DEVELOPMENT FACILITATIVE TEAM (DFT)
HEARING OCTOBER 2, 2024
UPDATE: 06/05/2024 Application Submittal

Project Number PR-2024-010446
SI-2024-00774-SITE PLAN DFT

RE: Site Plan Amendment for new construction

APPLICANT RESPONSES TO THE STAFF COMMENTS:

3 SW1 DUMPSTER ENCLOSURE PLAN AND DETAILS

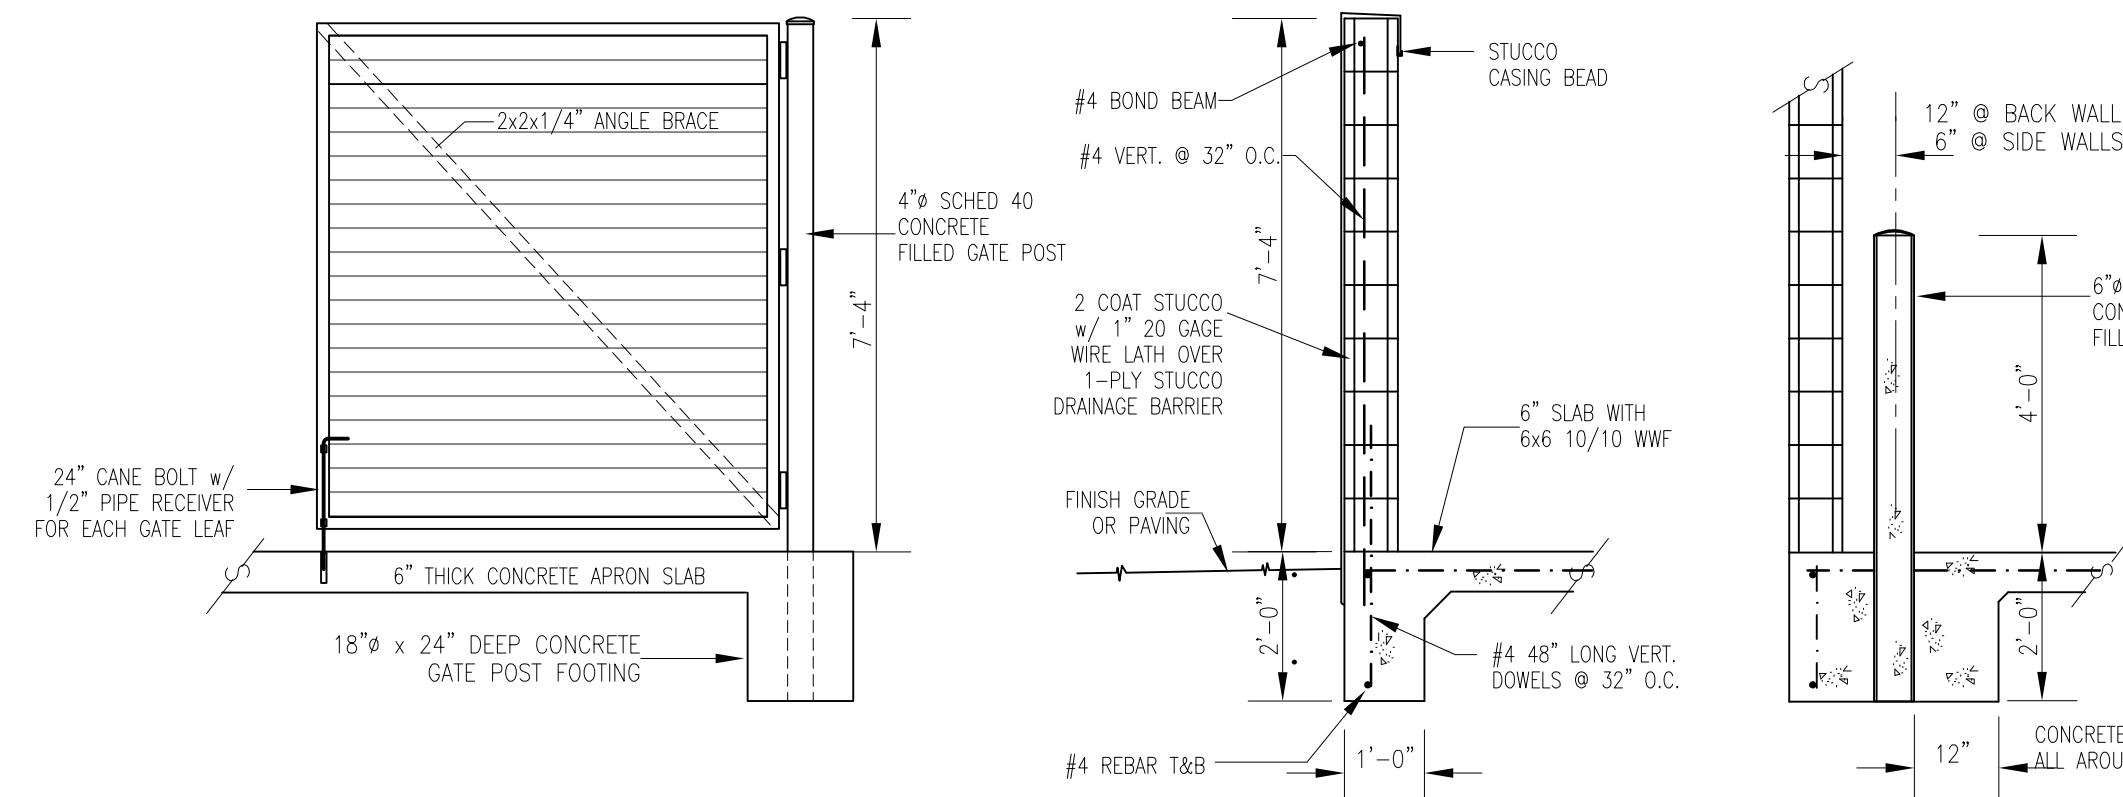
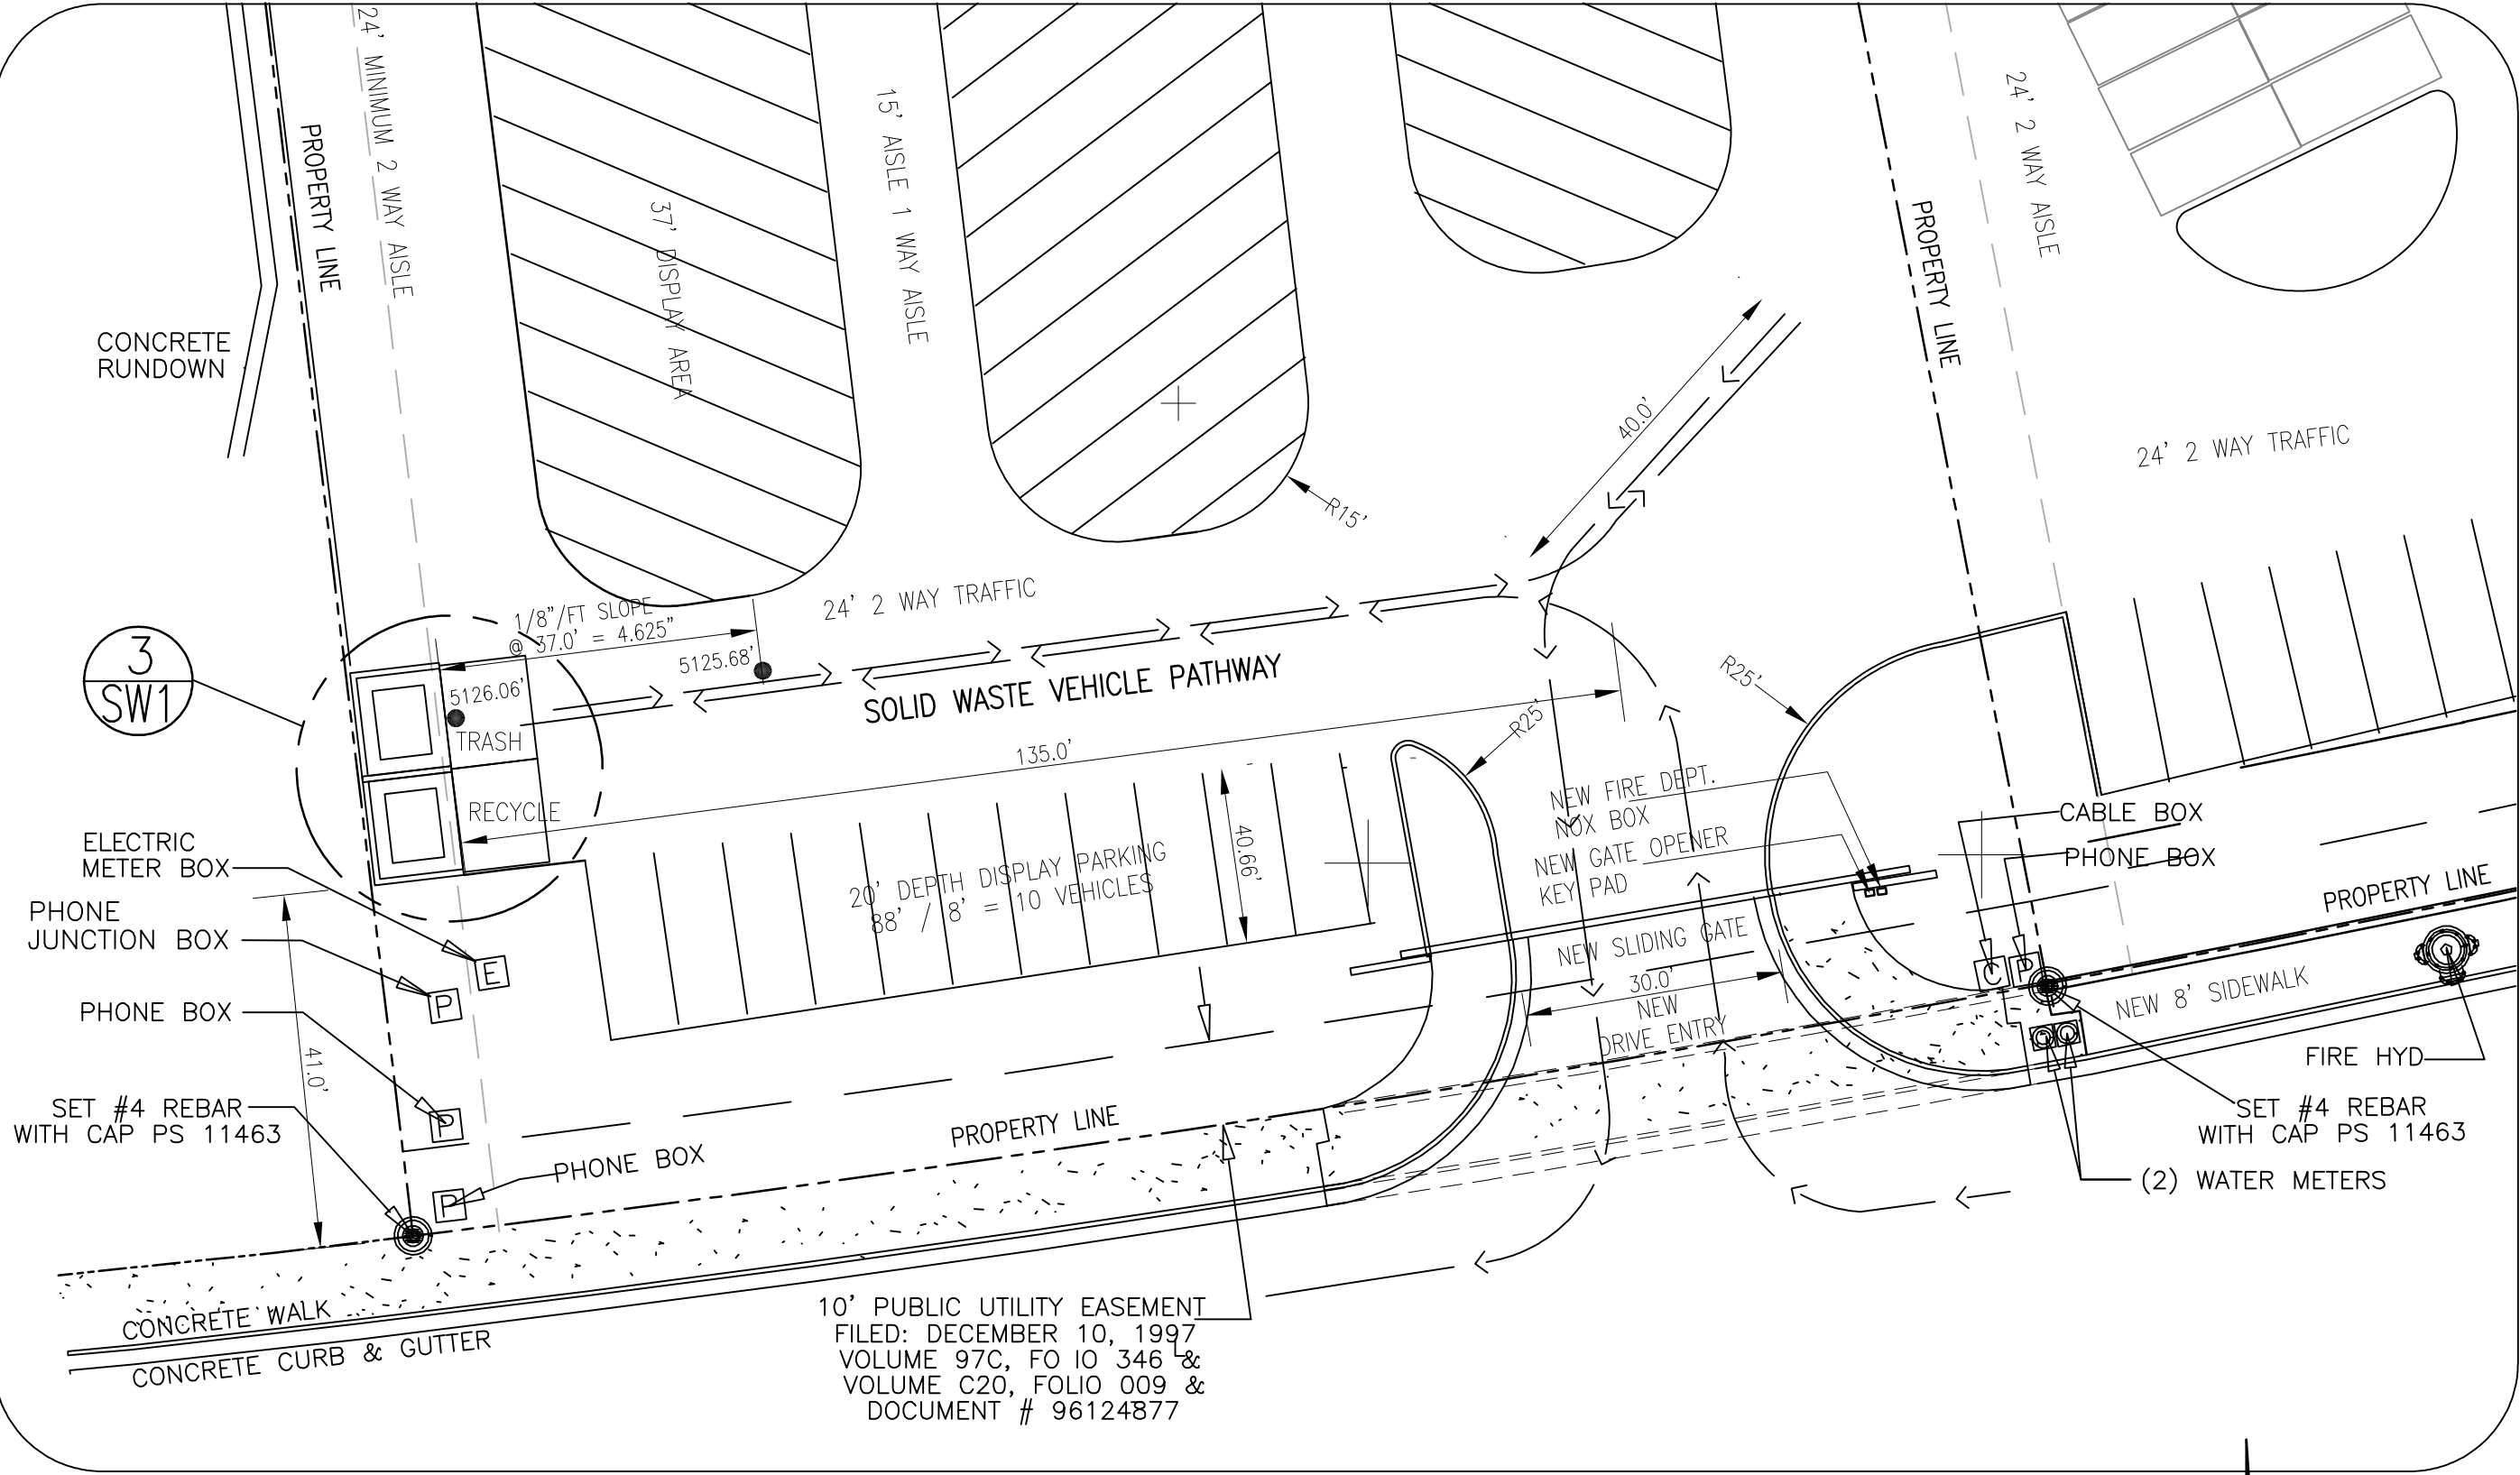
Outdoor loading, service, and refuse areas shall be integrated into the building design if possible, or shall be located where they are not visible from streets, City parks, Major Public Open Space, trails, or major arroyos adjacent to the lot or from adjacent properties with low-density residential development to the maximum extent practicable.

SOLID WASTE REFUSE CONTAINERS ARE SCREENED FROM PUBLIC VIEW BY STUCCO FINISHED WALLS 7'-4" IN HEIGHT

## Landscape Plan

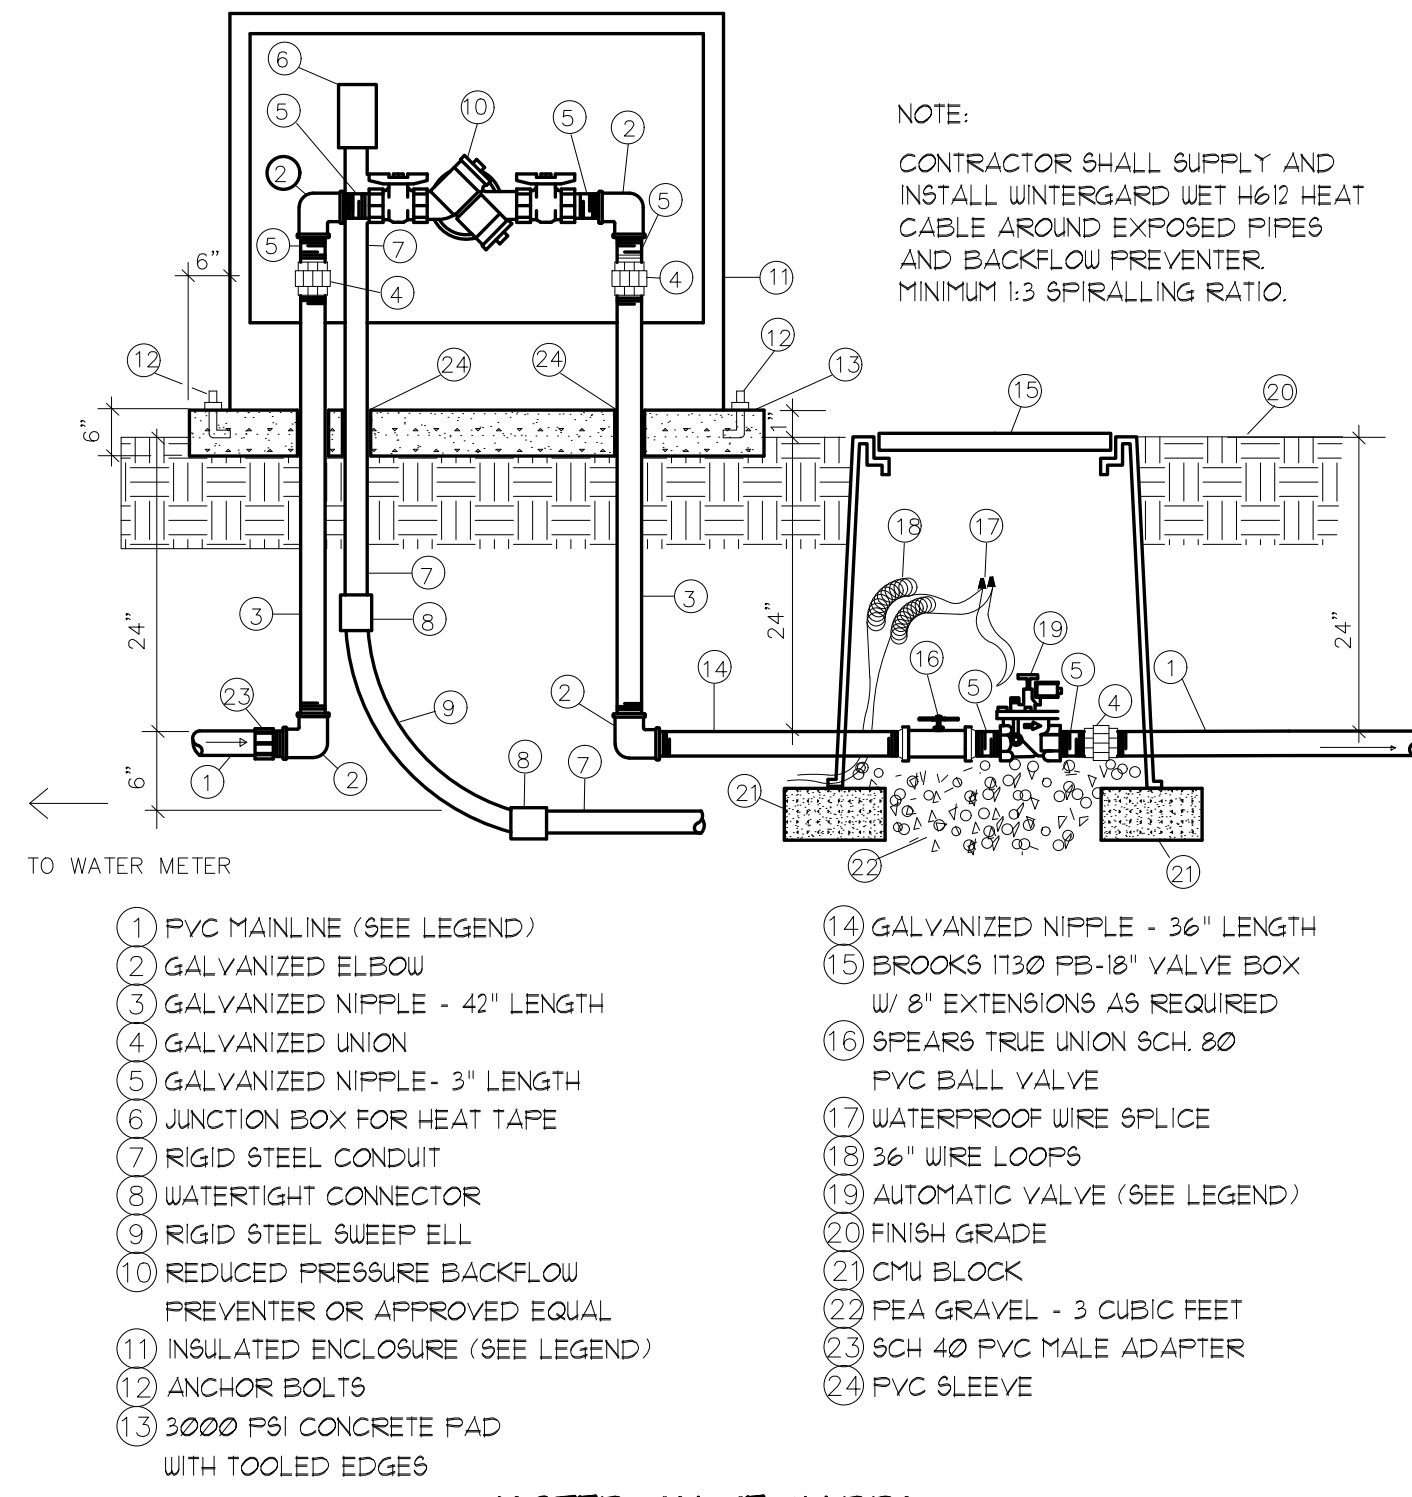
- There is a large amount of landscaping on the landscaping plan. Clarify the landscape calculation of the net lot area. Calculations must show how the entire development meets the minimum requirement(s).

- Clarify the details for the 100 ft landscape areas and how/where berming screening areas are being used to meet the requirements of the Clifford Park plan. *See snips below referencing the plan standards.
- Per IDO section 5-6(C)(2)(a) a minimum of 15 percent of the net lot area of each development shall contain landscaping. However, the Clifford West Plan has separate requirements.

See Mitchell Landscape Plan

The IDO landscape coverage requirement is 15% of the Net Lot Area. The CWBP landscape coverage requirement is 18% of the Net Lot Area. The actual landscape coverage as shown on the Landscape Plan will be 20.8%.
